LSC Responses to EPC
 PCD TIS Redline Comments

Cottages at Mesa Ridge¹
 Traffic Impact Analysis
 (LSC #S214580)
 January 17, 2022

**APISHAPA HEIGHTS - W/ GARAGE TYPICAL SECTION - 1
(PRIVATE DRIVEWAY)**

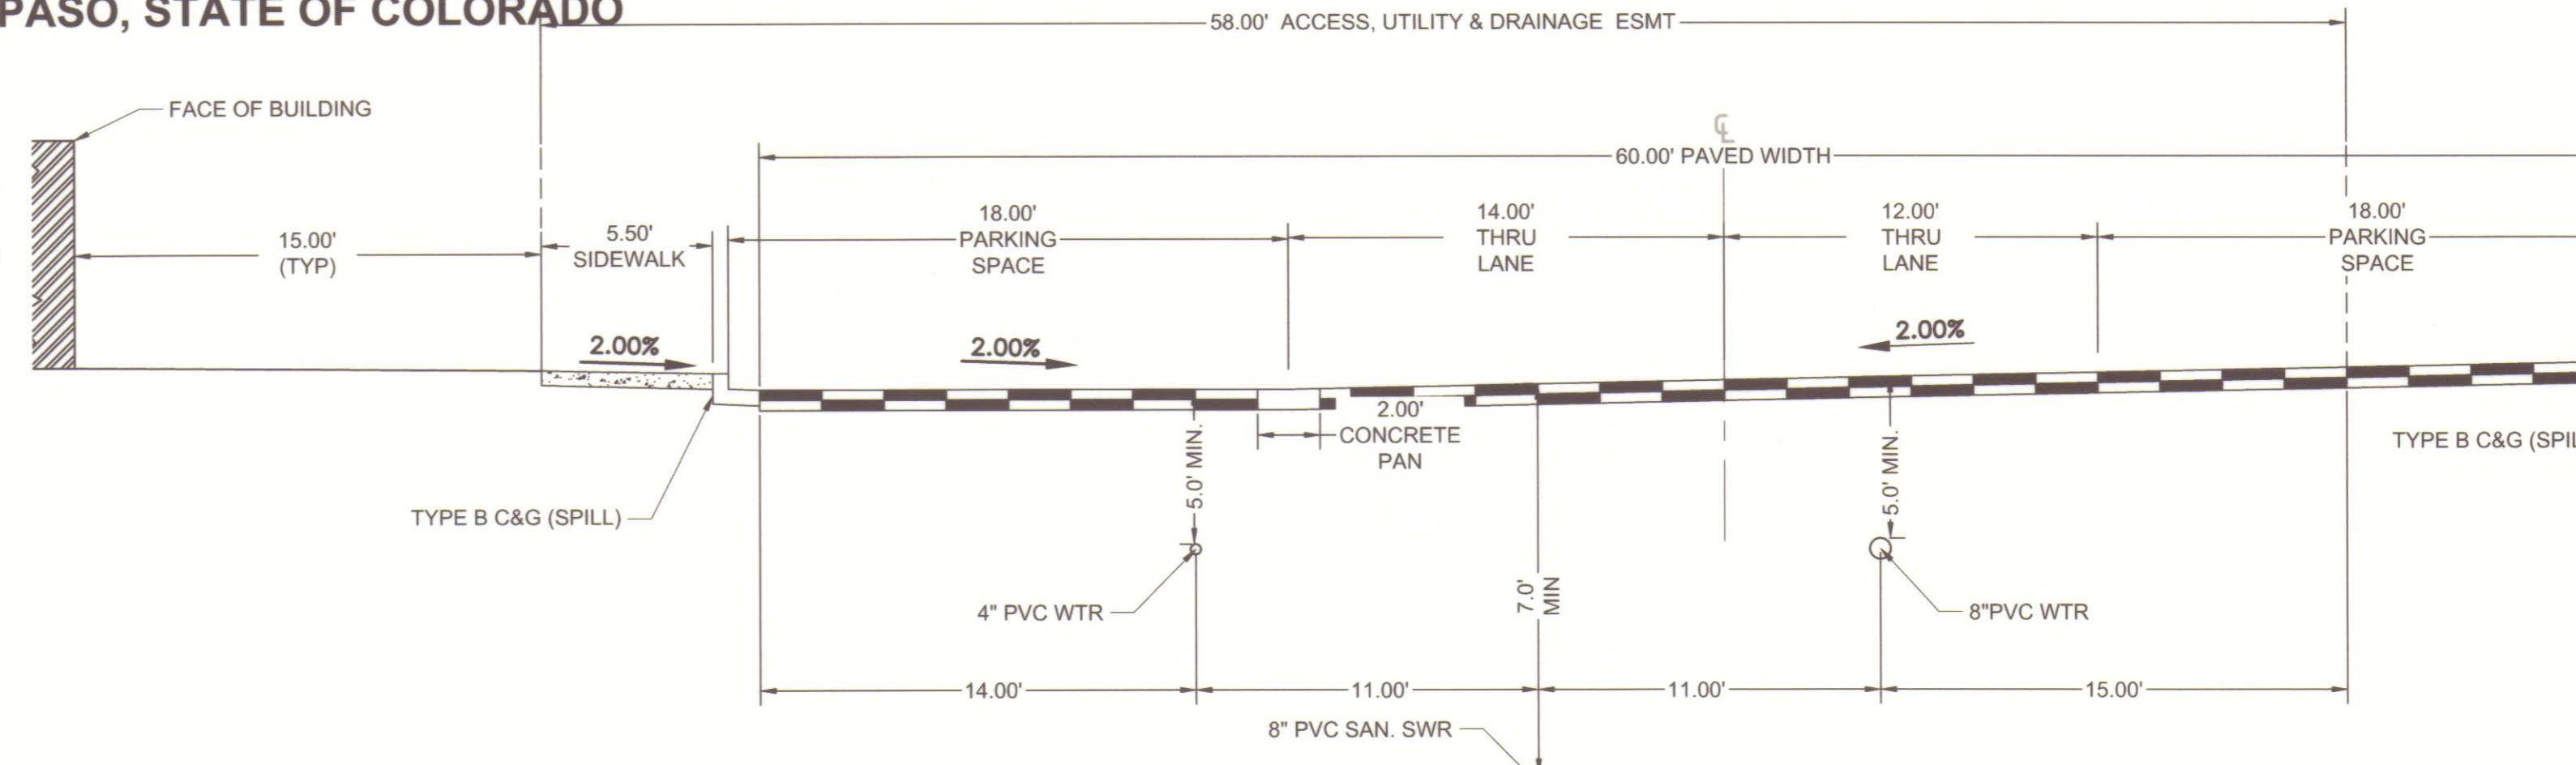
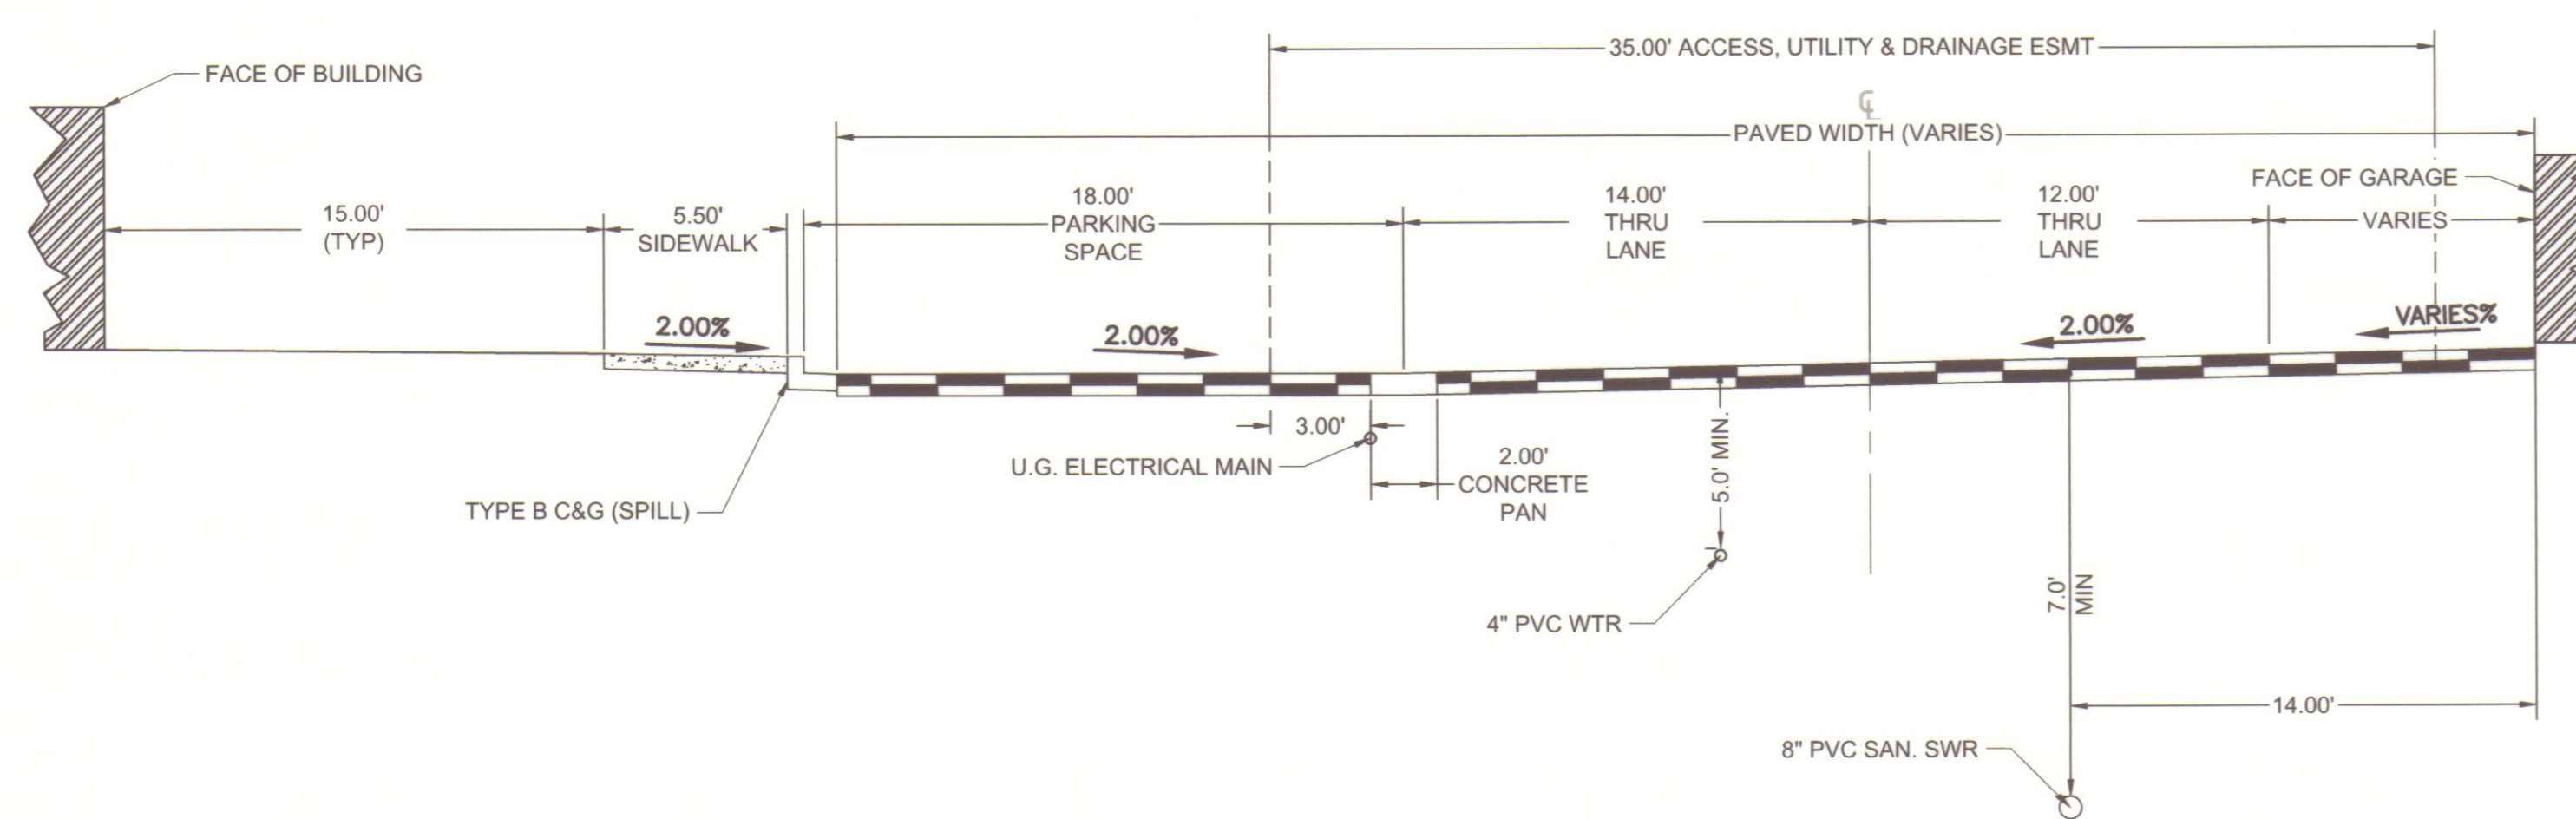
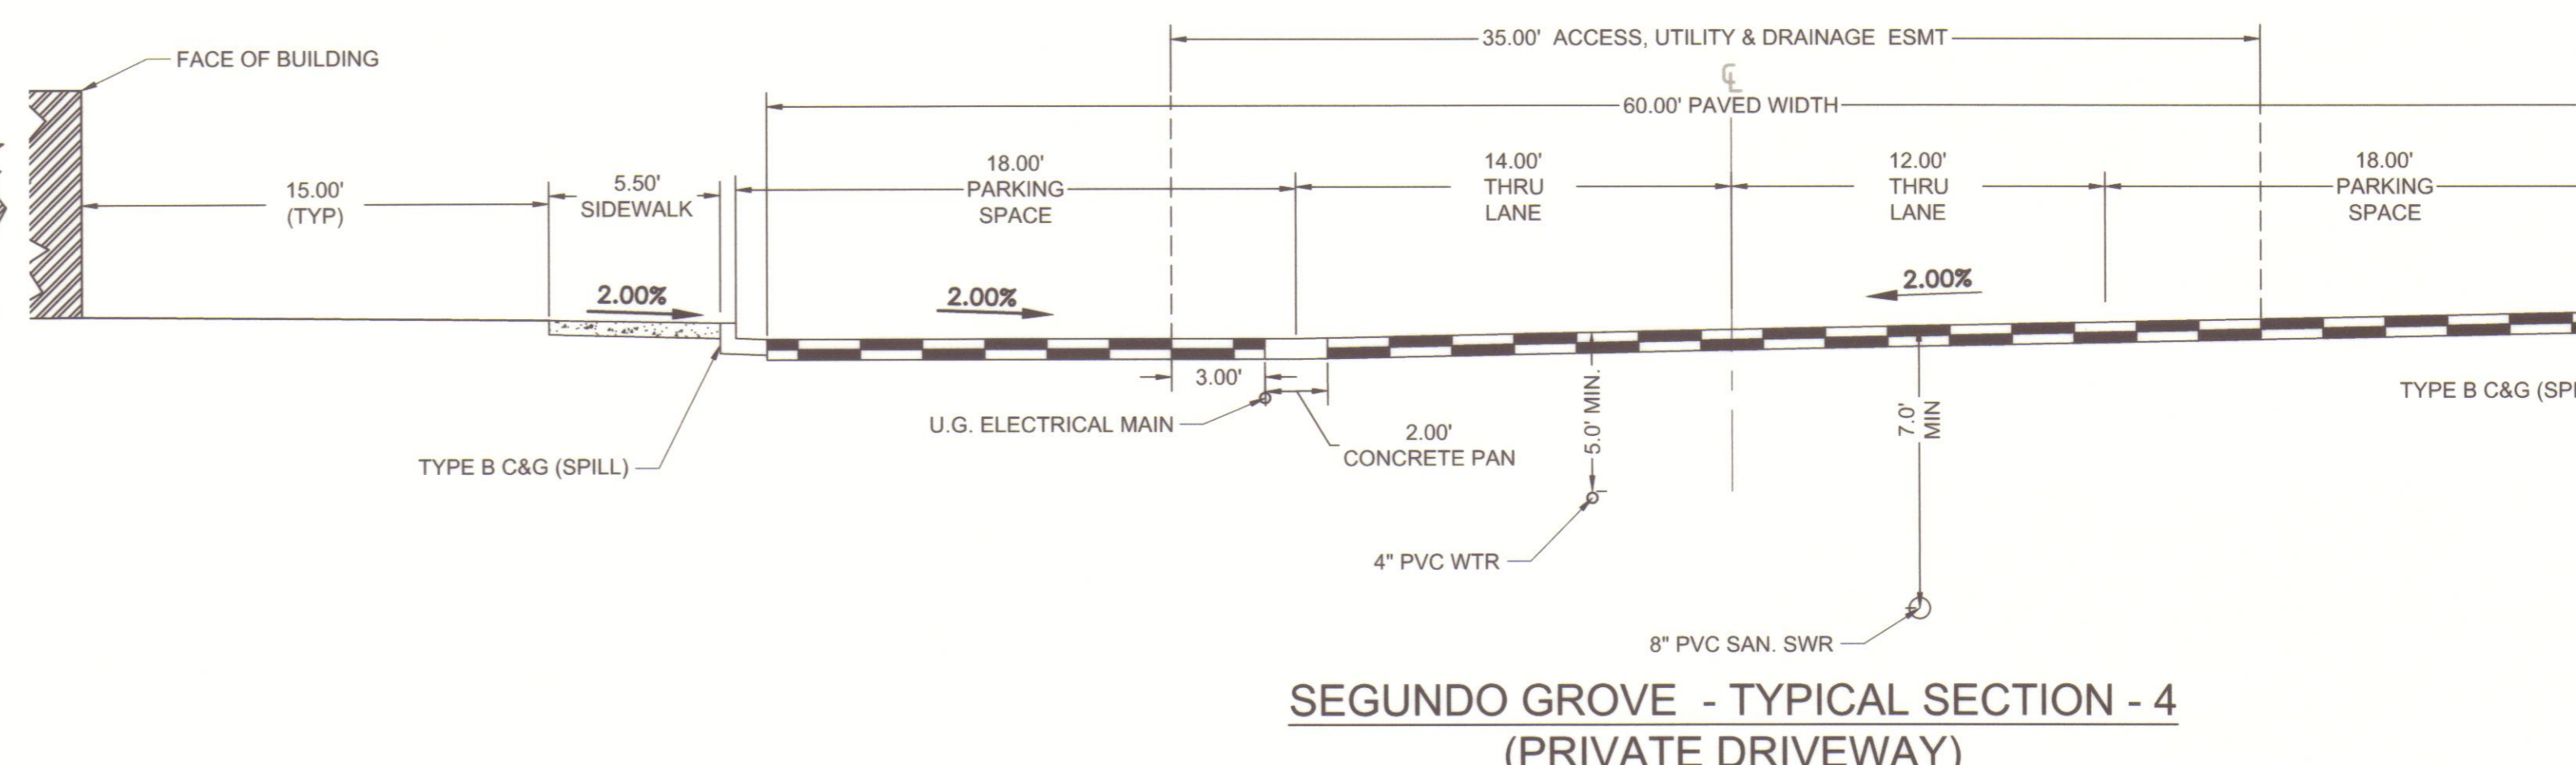
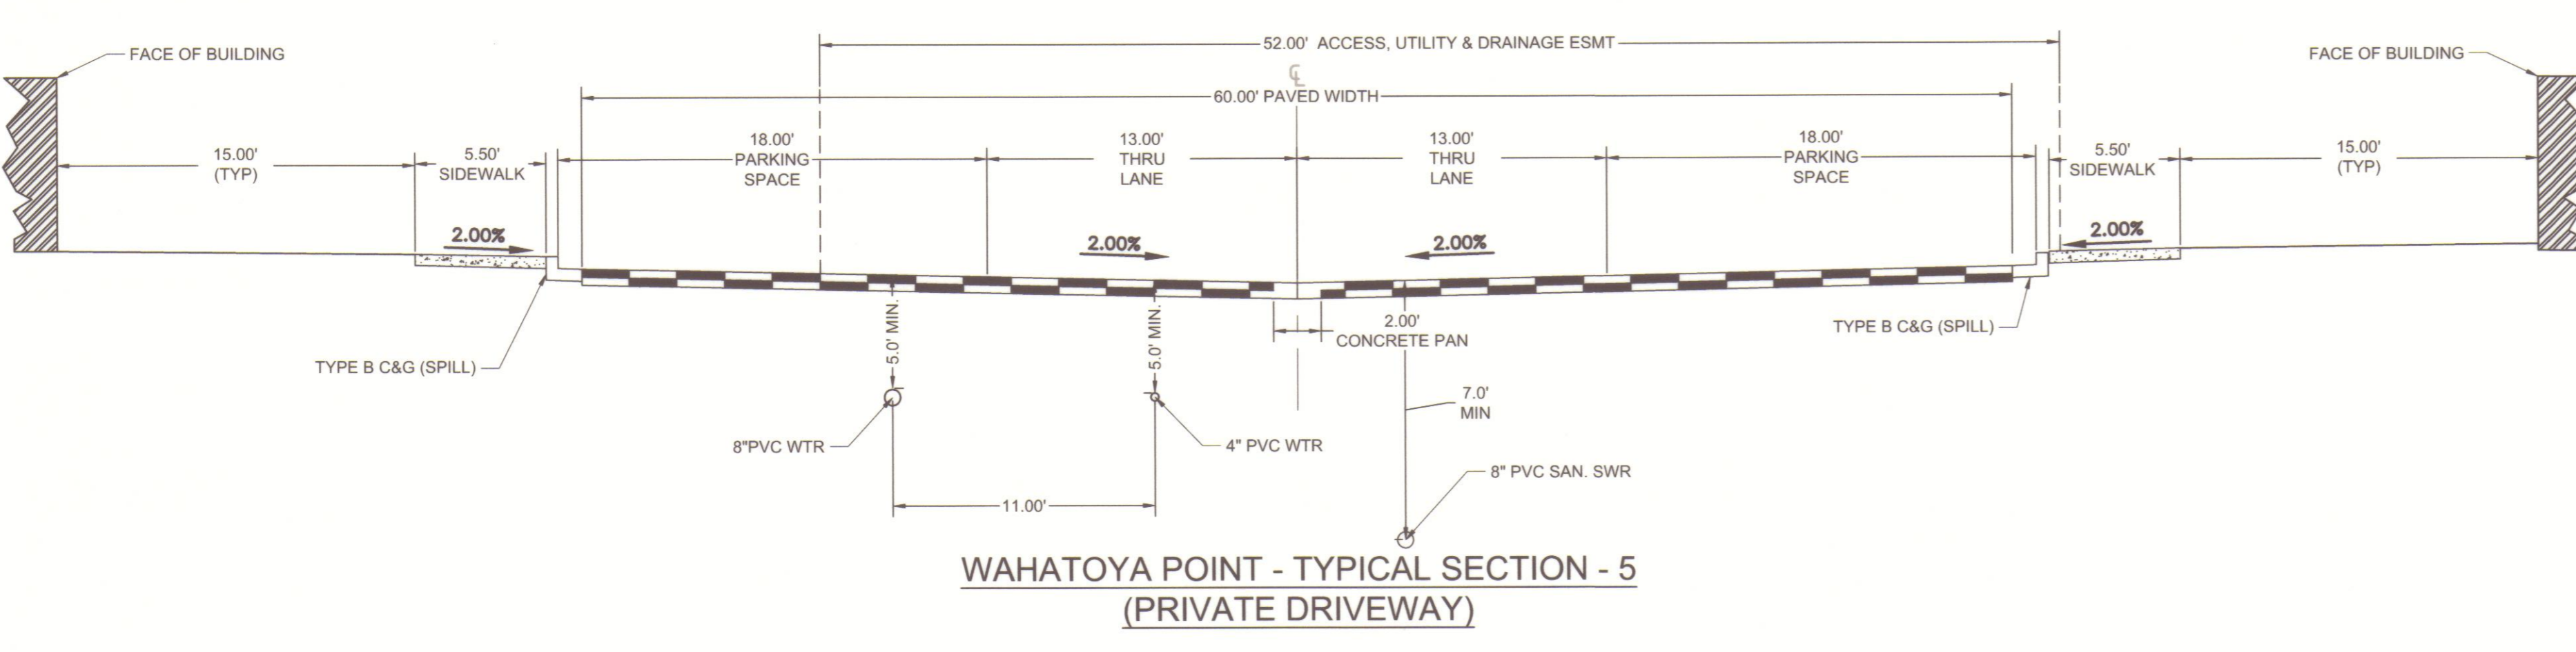
³
Please revise this to indicate private driveways/drive aisles to match what is proposed on the preliminary plan.

Please revise this to indicate private driveways/drive aisles to match what is proposed on the preliminary plan.

LSC Response: Revised as requested.
